RE: ENGINEER'S CERTIFICATION FOR P.M.I. WAREHOUSE
(C-17/D15) ENGINEER'S STATEMENT DATED AUGUST 30, 1989

RE: REVISED DRAINAGE PLAN FOR P.M.I. WAREHOUSE (C-17/D15)
REVISION DATED JULY 26, 1989

RE: REVISED DRAINAGE PLAN FOR P.M.I. WAREHOUSE (C-17/D15)
RECEIVED JULY 26, 1989

RE: REVISED DRAINAGE PLAN FOR P.M.I. WAREHOUSE (C-17/D15)
RECEIVED JUNE 22, 1989

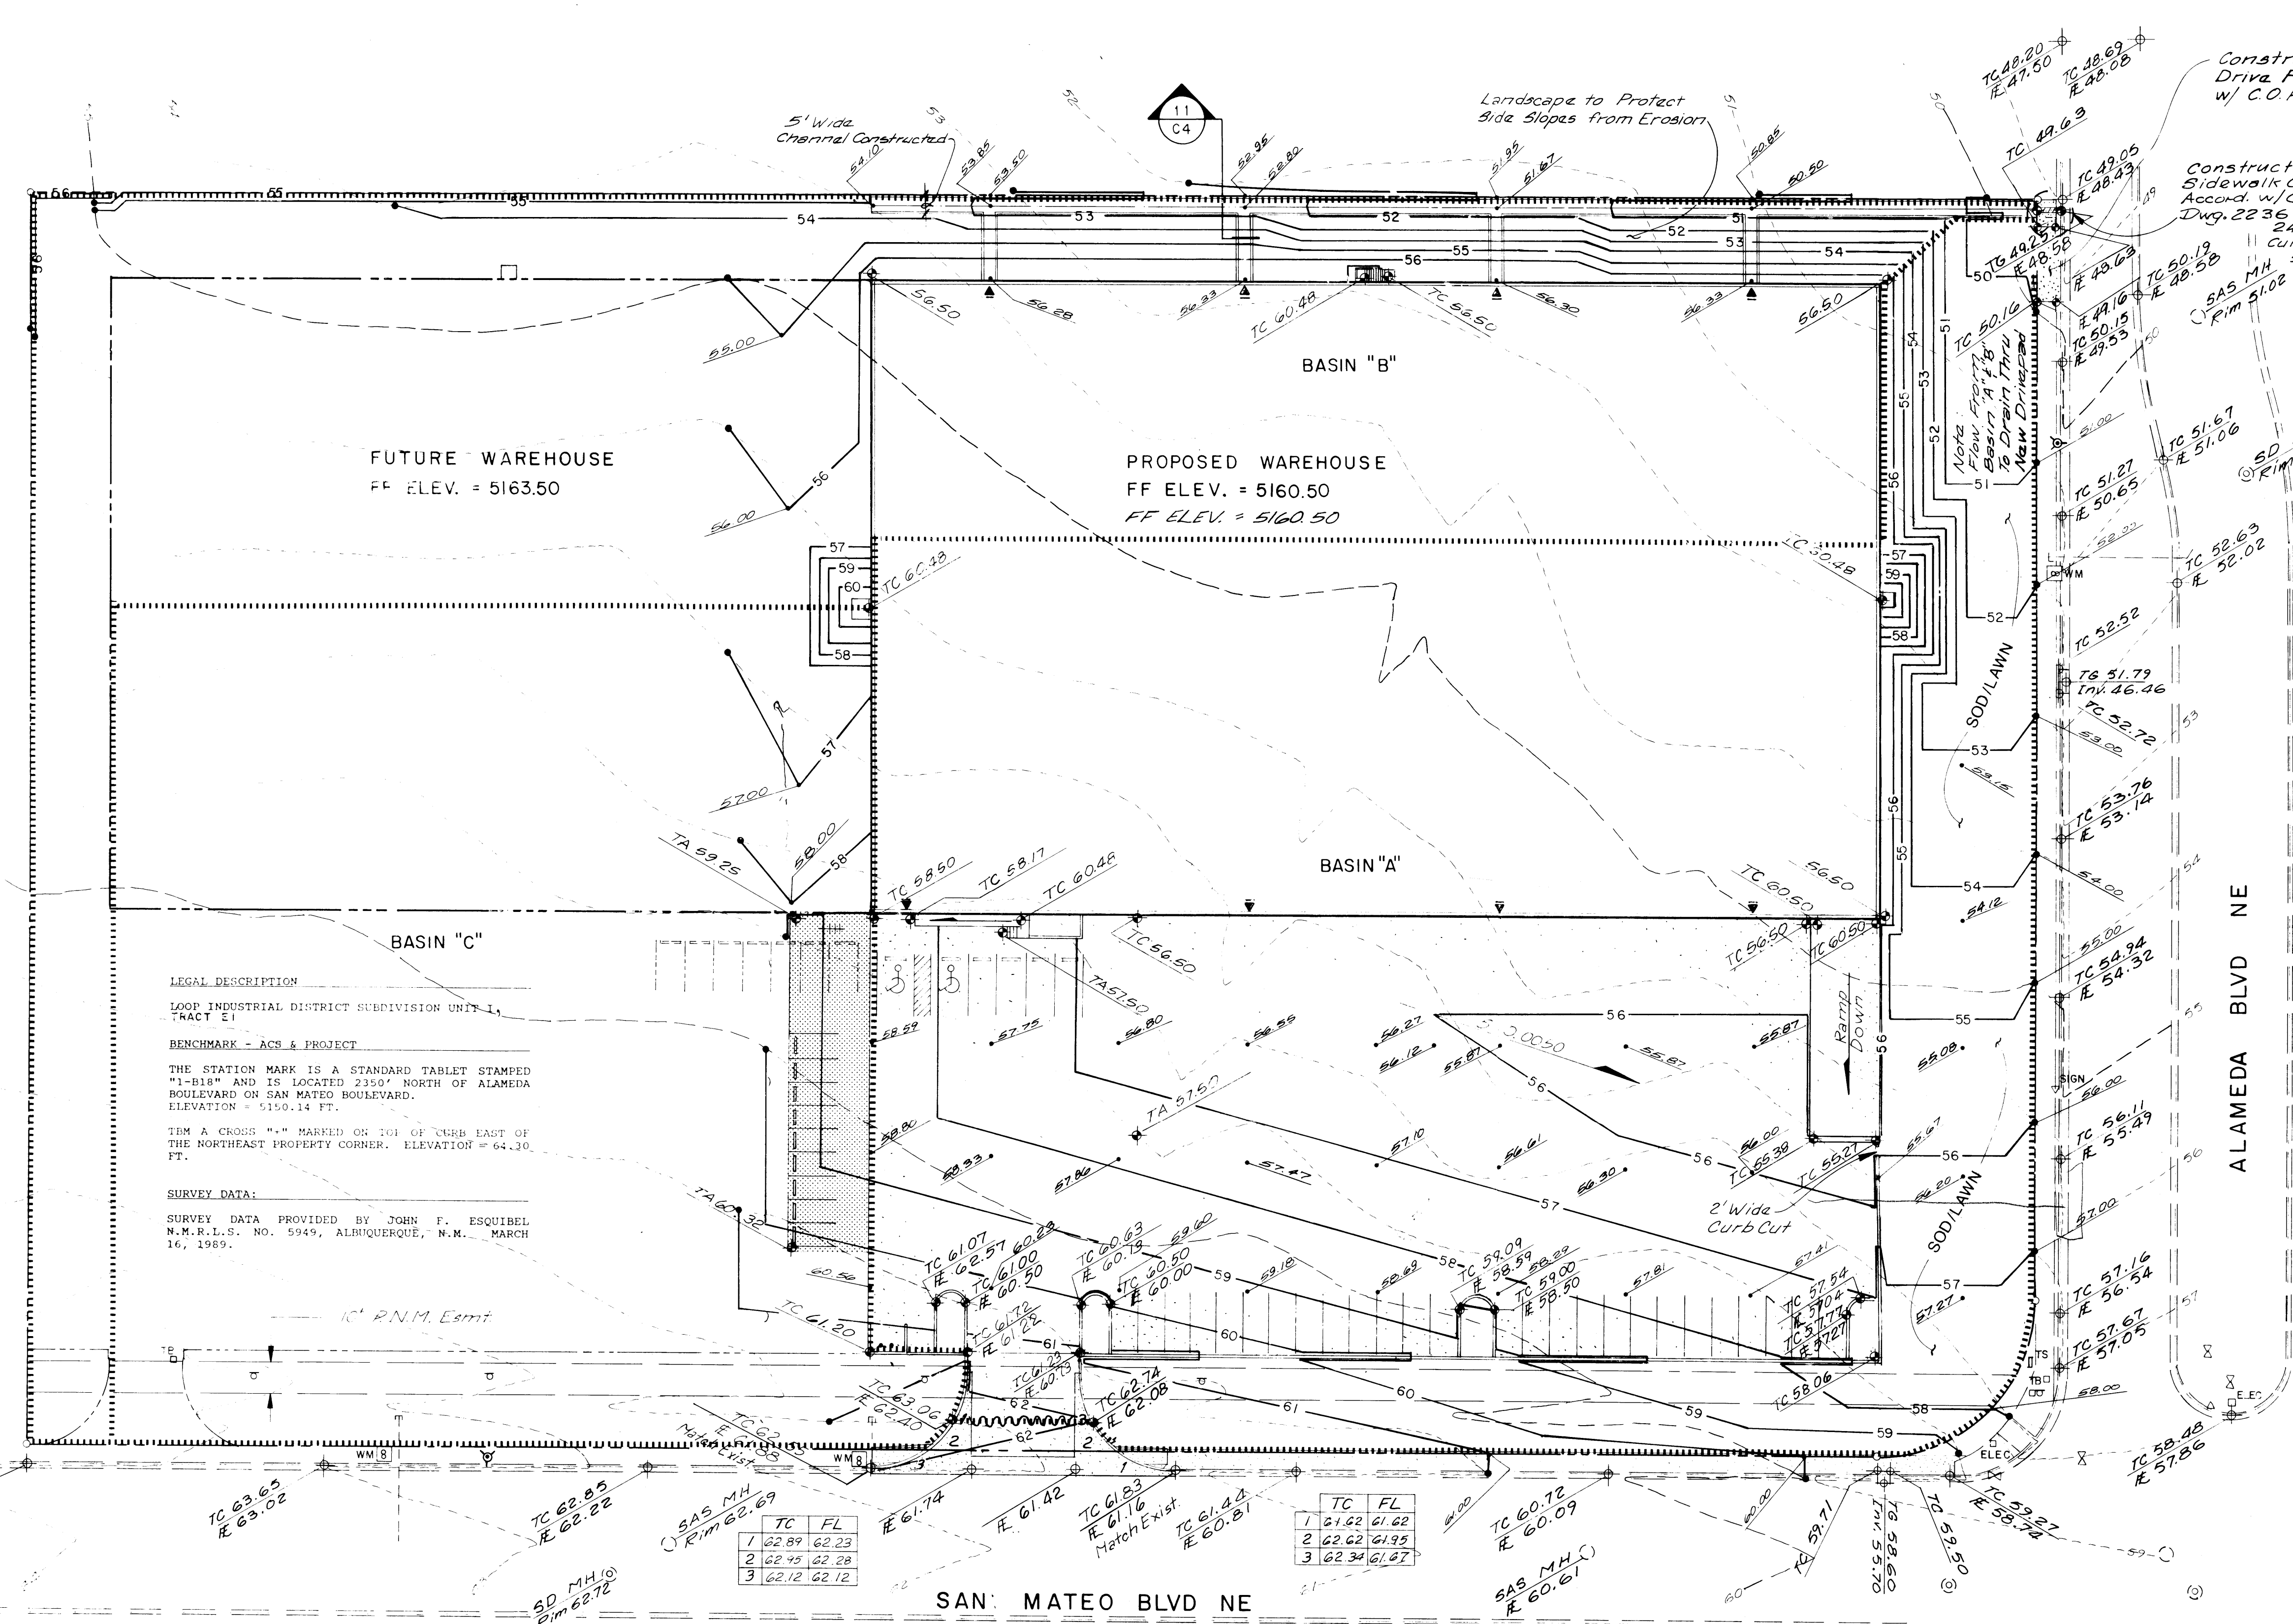
1. Traffic Engineering will not allow for a standard 24' wide drive pad to be constructed for the sole purpose of developed runoff discharge.
2. If you can redesign your outlet point to not cause damage by letting the Q_{100} overflow the sidewalk culverts, then you will be allowed to release only the Q_{10} through the sidewalk culverts. Our concern is damage to the property to the west. Protection must be provided so that the overflow goes into the street.
3. Recompute your basins and show what the accumulated Q_{10} will be.

1. Your resubmittal indicates that between Basin A and B, and eventually Basin C, you will have an accumulated $Q = 19.35$ cfs. All will be routed to the proposed sidewalk culvert which can only handle 4.73 cfs. Please address.
2. What type of landscaping or vegetation do you propose for erosion control from the notch on the curb to the proposed sidewalk culvert?
3. How do you propose to get the runoff from Basin A & C into the sidewalk culvert?
